From: alan.story@hertfordshire.gov.uk
Sent: 10 June 2015 09:25
To: Planning
Subject: Planning application S6/2015/1119/OR - Everest Ltd Everest House

District ref: S6/2015/1119/OR
HCC ref: WH/148/2015
HCC received: 04/06/2015
Area manager: James Dale
Case officer: Alan Story

Everest Ltd Everest House
Sopers Road
Potters Bar
EN6 4SG

Prior approval for the change of use from Class B1 (Office) to Class C3 (Dwellinghouses)

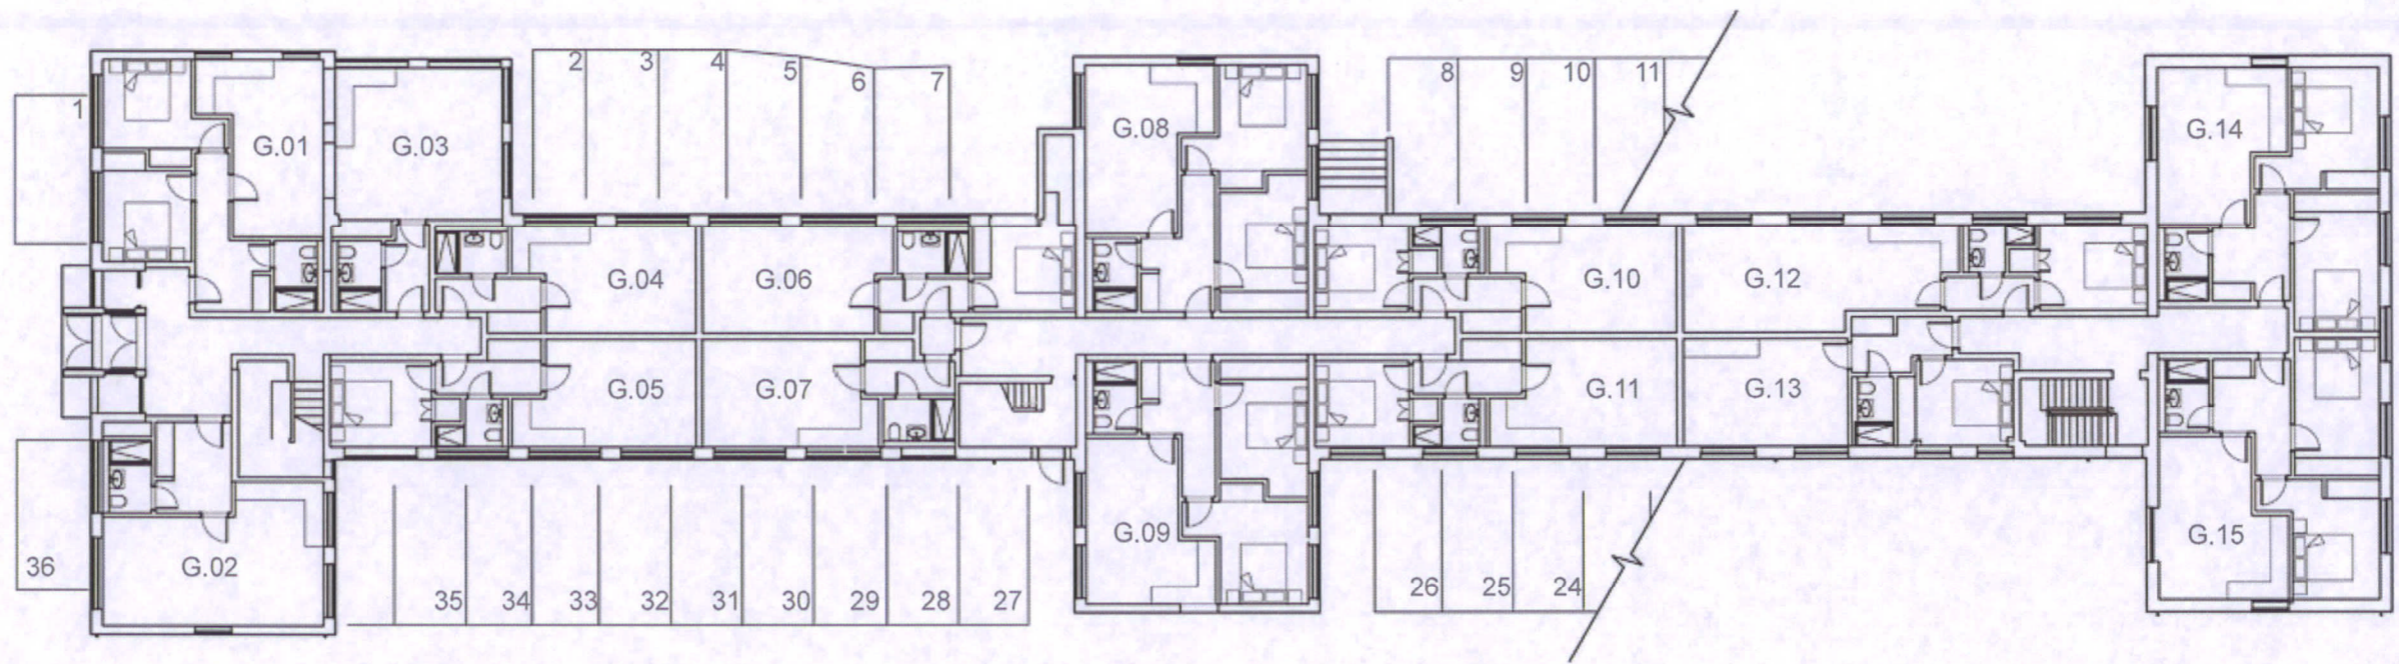
Parking is provided at 43 spaces to serve the 45 flats, and the LPA shall be responsible for determining the acceptability of such provision against their parking standards, however any overspill parking would be

Cycle parking for 44 bikes is suggested, demonstrated on plans (lower ground proposed) as being located as a mix of internal and external spaces. The provision of such cycle parking is welcomed, supporting and encouraging the use of more sustainable forms of travel, and particularly noted given the proximity of the site to national rail services (Cuffley station, some 150m from the site).

I would observe that refuse stores do not enjoy a direct connection to outside, representing potential difficulties to waste collection operatives, and the views of the LPAs own waste collection services team should be sought in this regard. I am satisfied that refuse vehicles are able to enter the site and therefore do not expect that any delays incurred with servicing would create an unacceptable disruption to general traffic movement in Sopers Road.
